**PLANNING REF: P/153/21/RES Land South of Summer Lane and West of
Pagham Road, Pagham**

**APPLICATION RESPONSE - HOUSING STRATEGY AND ENABLING MANAGER ARUN
DISTRICT COUNCIL**

Rev.	Description	DATE	DB / CB
Date		Oct' 21	
Drawn By/Checked By		DY / HJE	
Scale		1:1250 @ A2	
Revision		-	
Project	Land South of Summer Lane, Pagham		
Title	Northern Affordable Housing Plan		
Dwg#	21.003.66		
Status	Planning

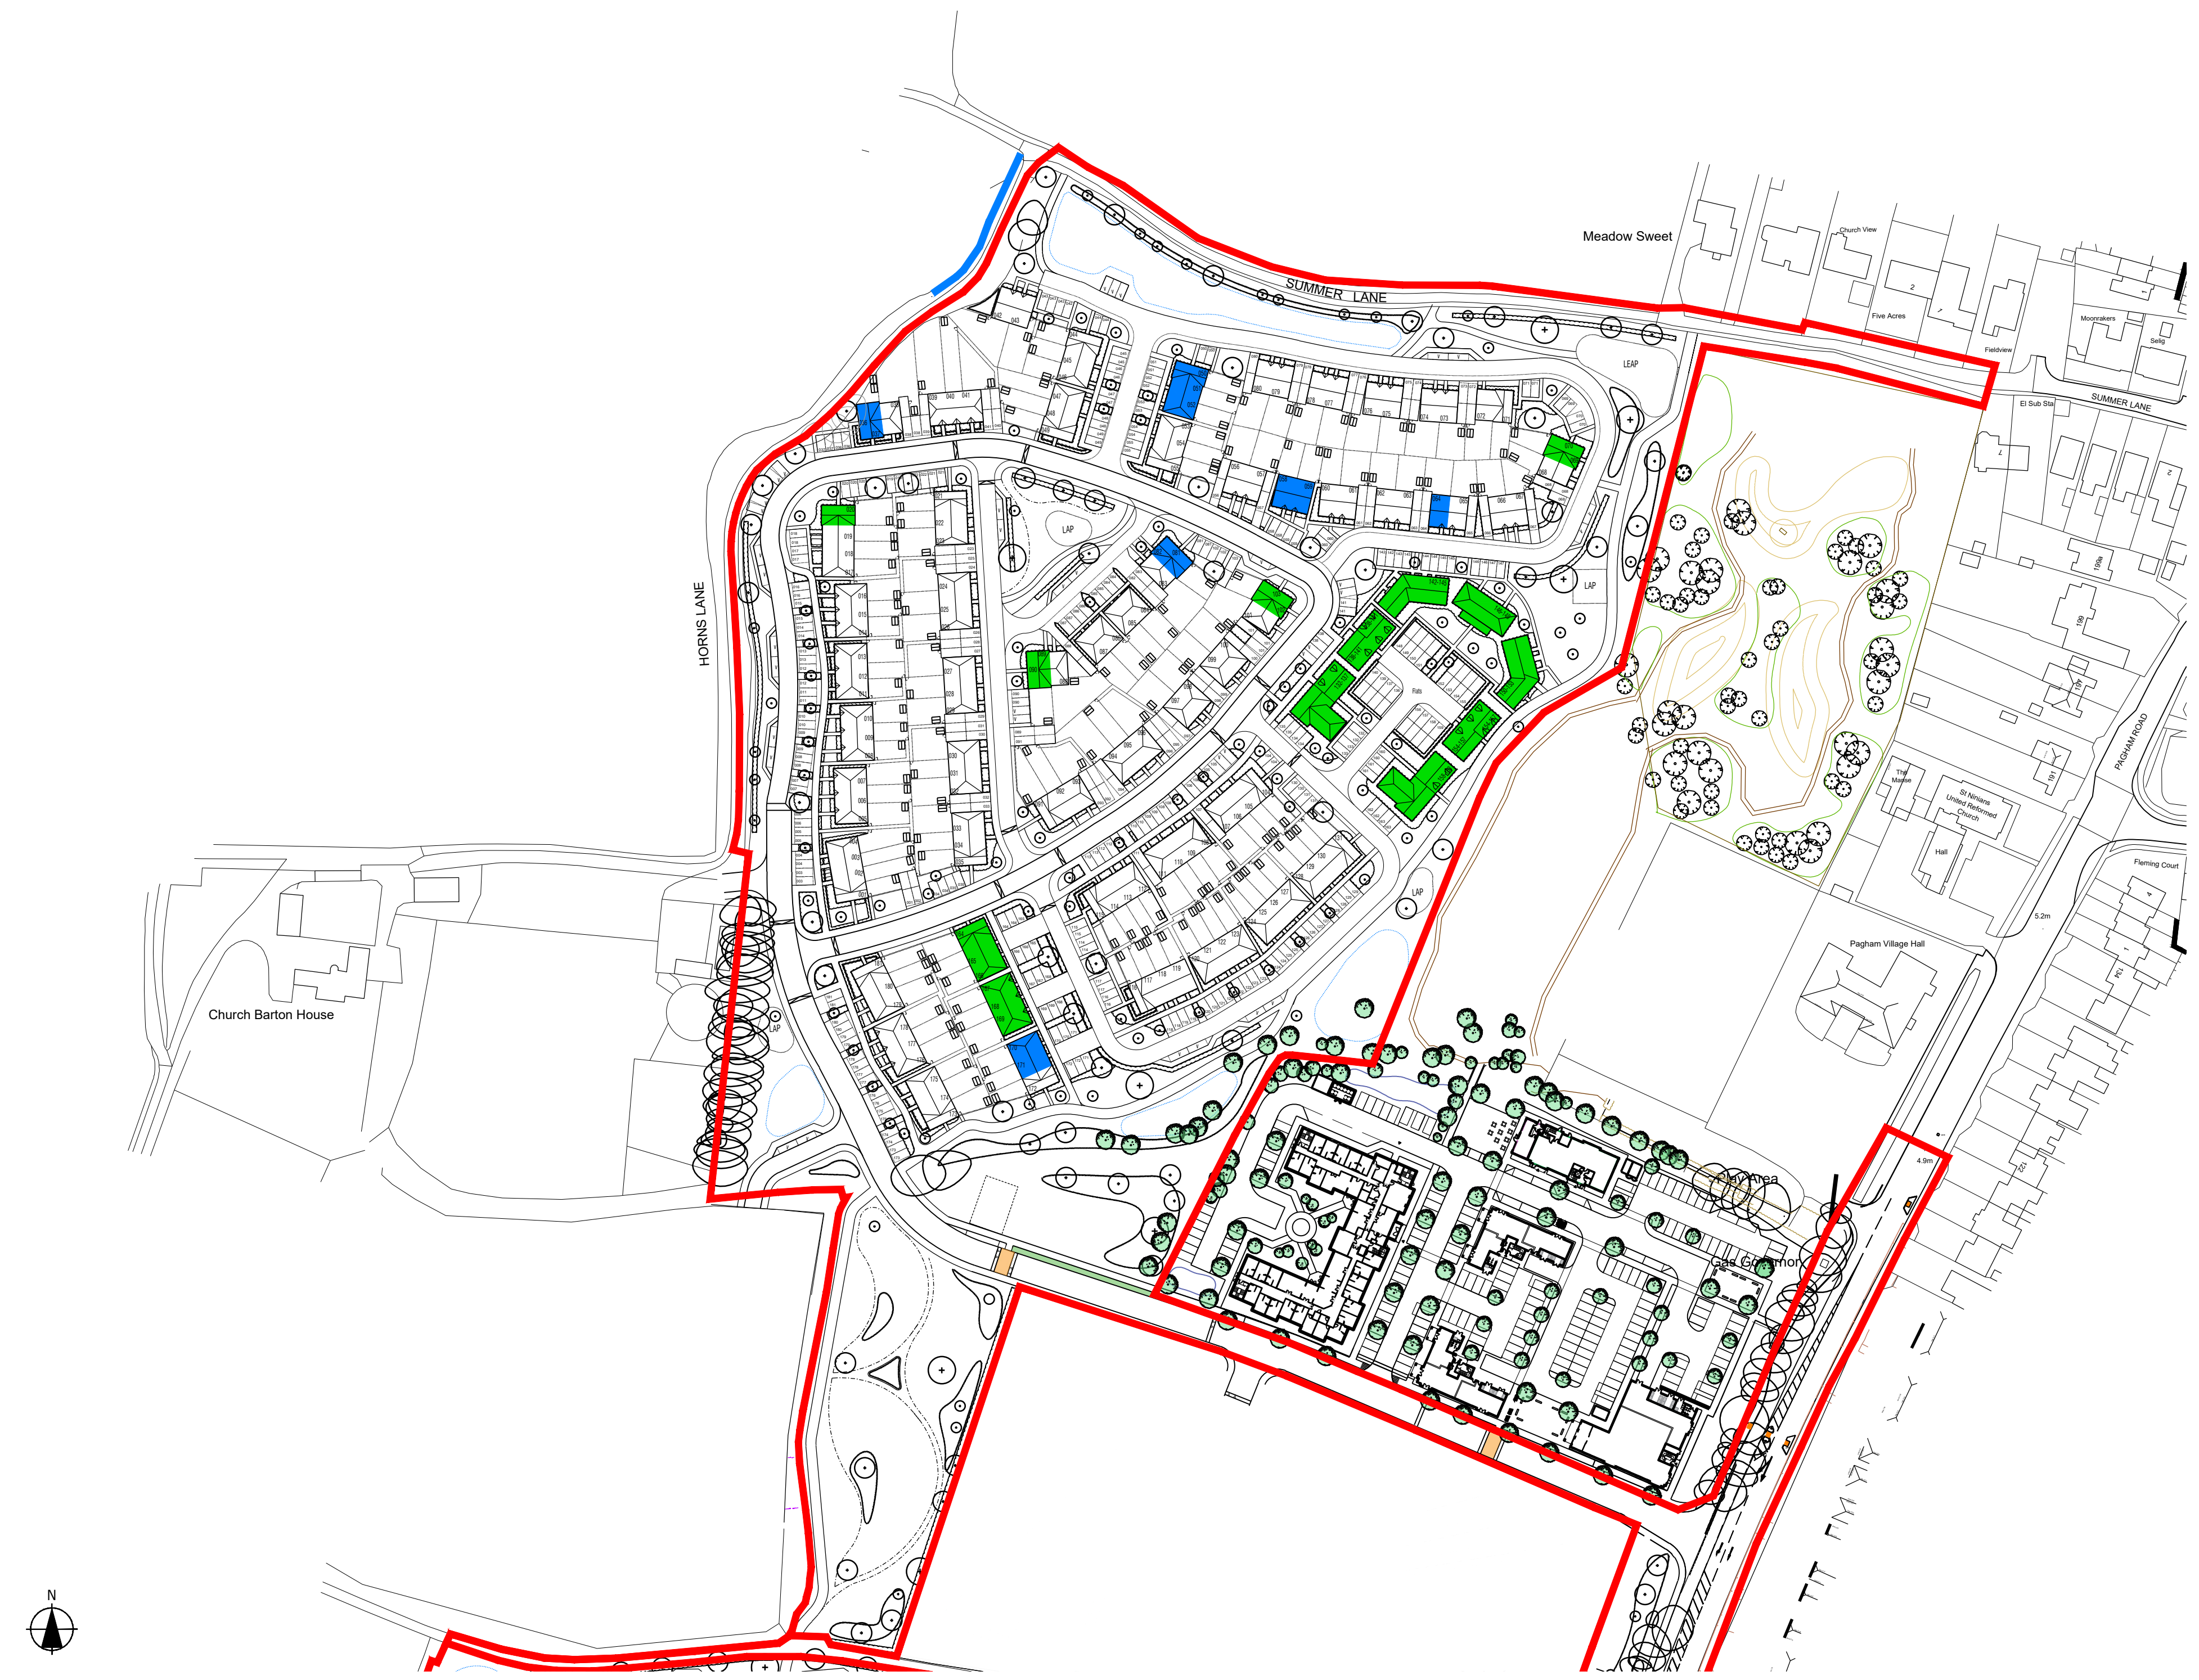
We have concerns regarding clustering of the affordable homes particularly in respect of the rented homes and would like to see the plan revisited to better distribute the affordable homes and ensure there are no clusters which total more than 10 dwellings.

We object to the application in the current form as we would anticipate a more equitable distribution of the affordable homes.
